Application for outline planning permission with some matters reserved for 45 No new dwellings and new access. This application also lies within the parish of Yapton. This application is a Departure from the Development Plan.

Land south of Burndell Road Ford

Thank you for your internet representation made on 1st June 2014 which has been recorded as '**an objection**' with the comments as follows:

TITLE: Proposed Access and Highway
Improvements Plan

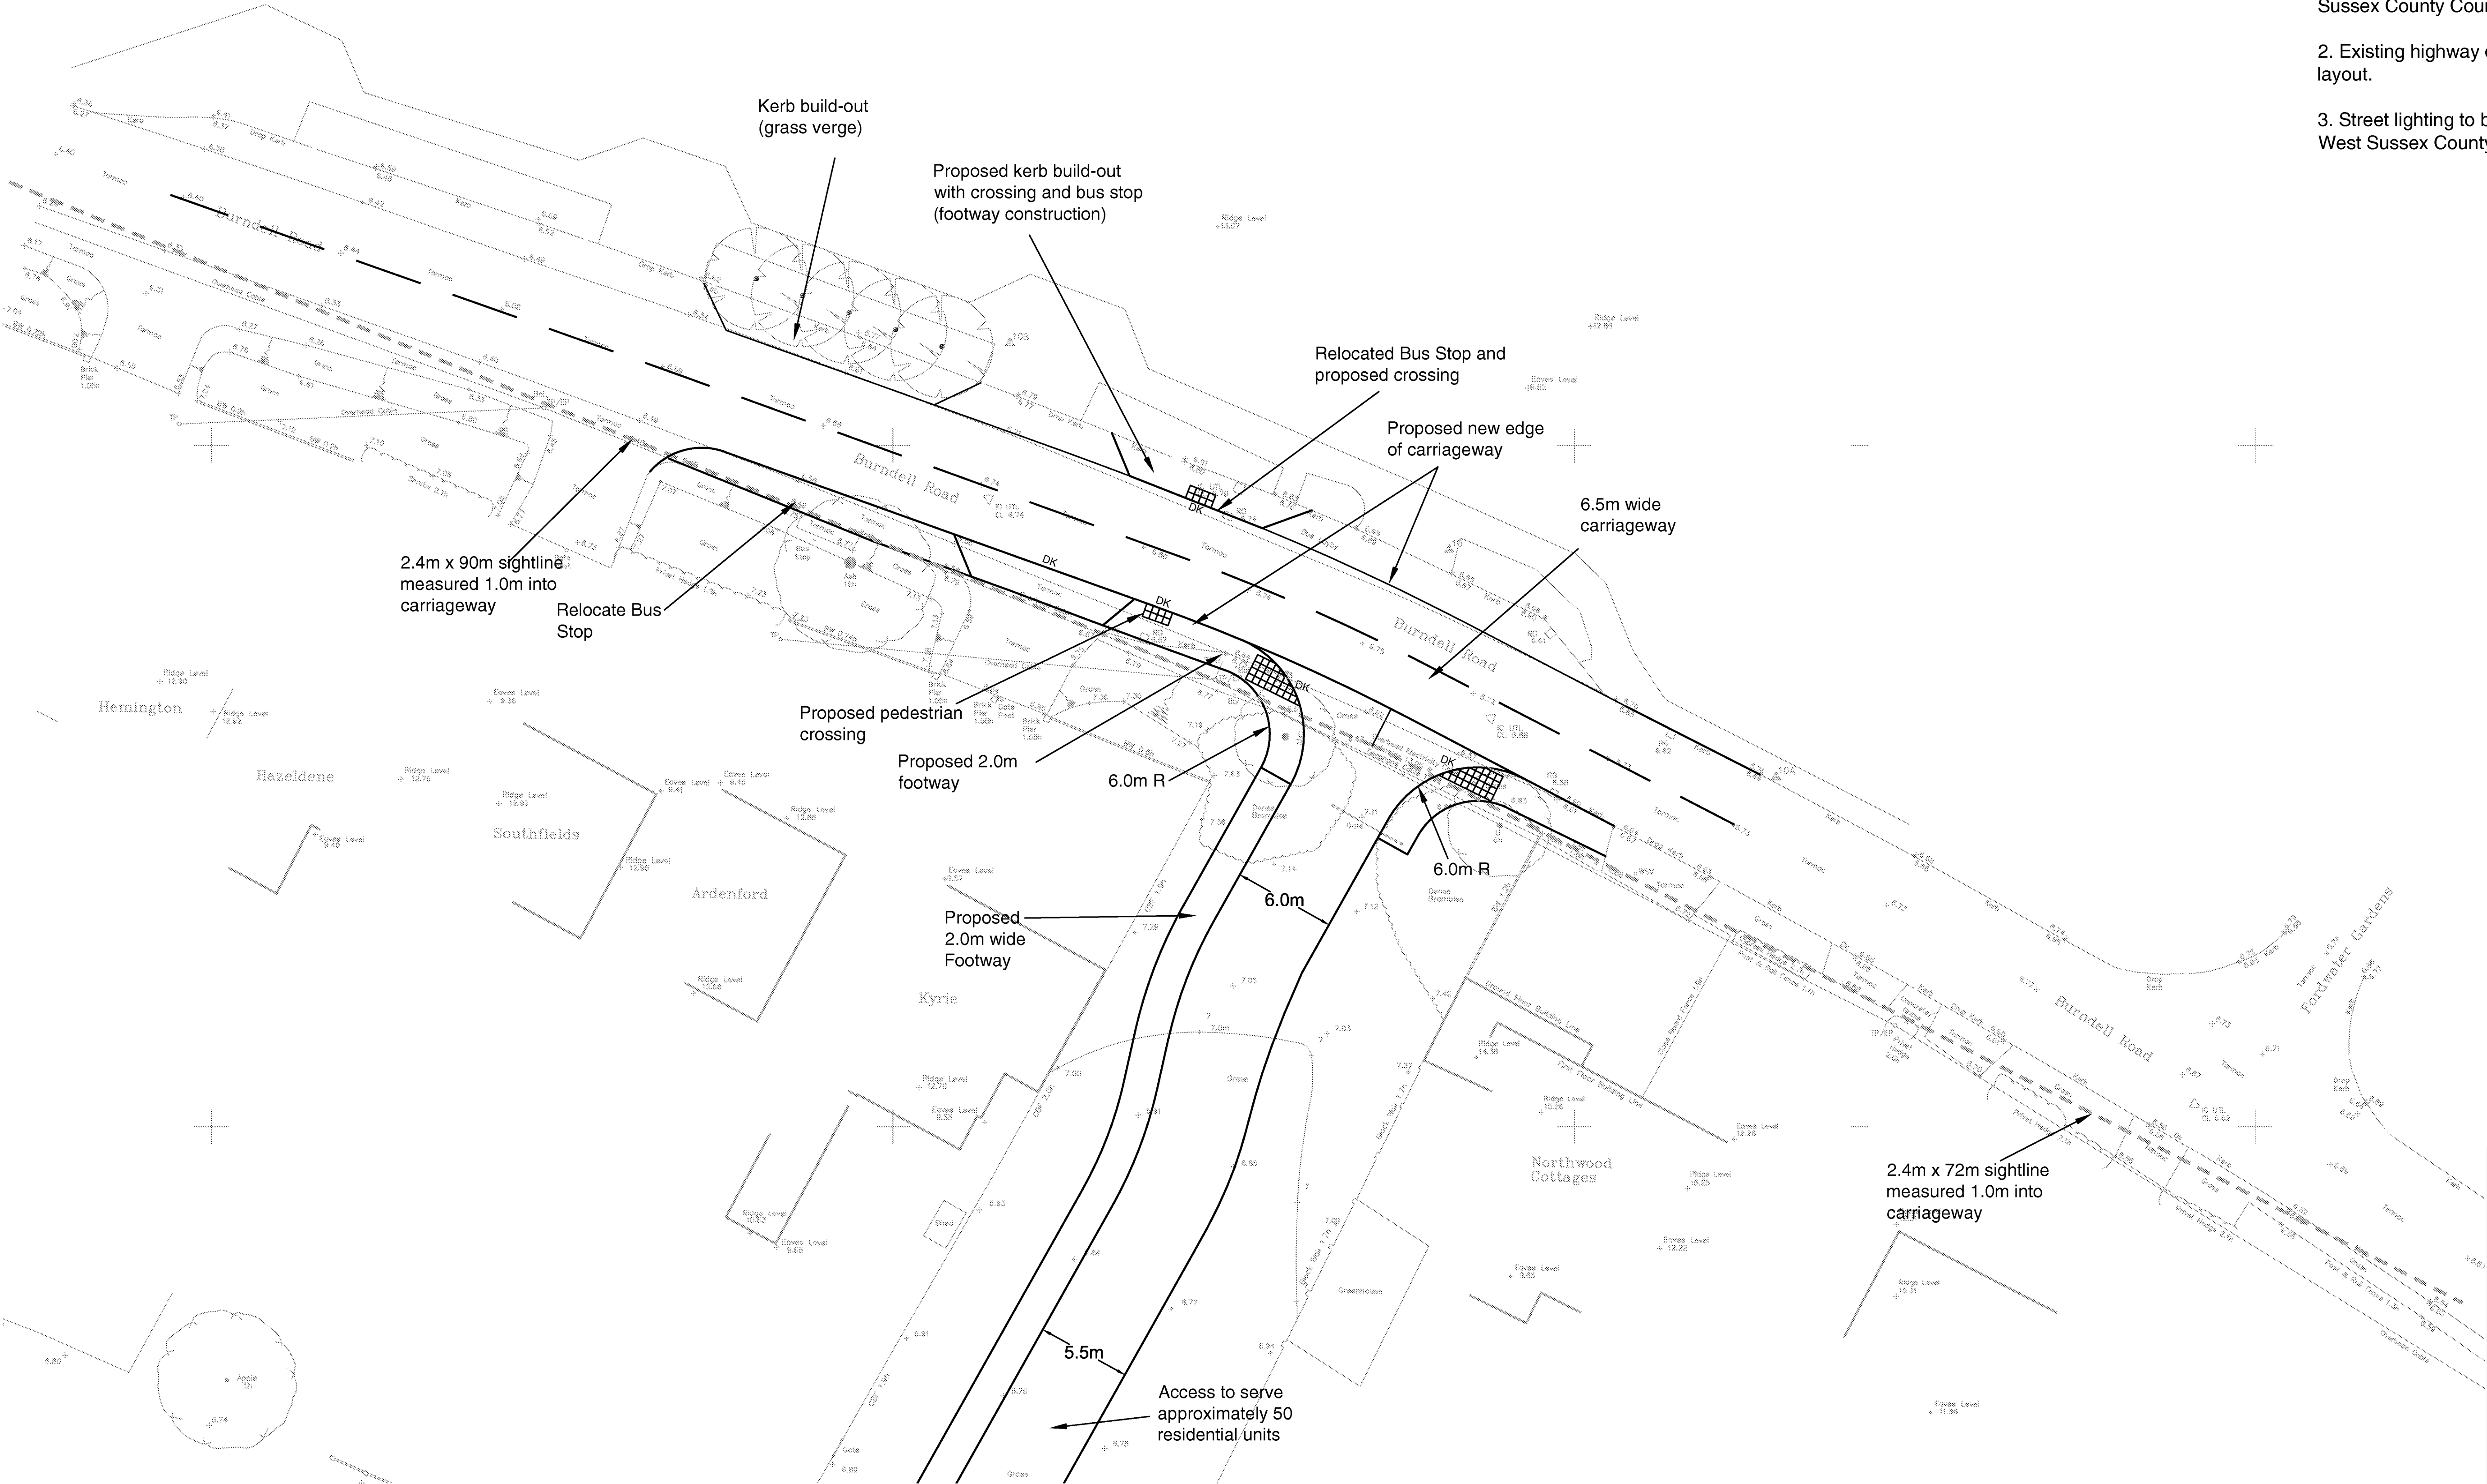
The proposed realignment of the road will only increase the risk and make entering and exiting properties difficult particularly if the lay bys are removed or narrowed. A possible solution would be for the proposed development to have access through Fellows Gardens. The lay bys are regularly used for parking by visitors clear of the highway.
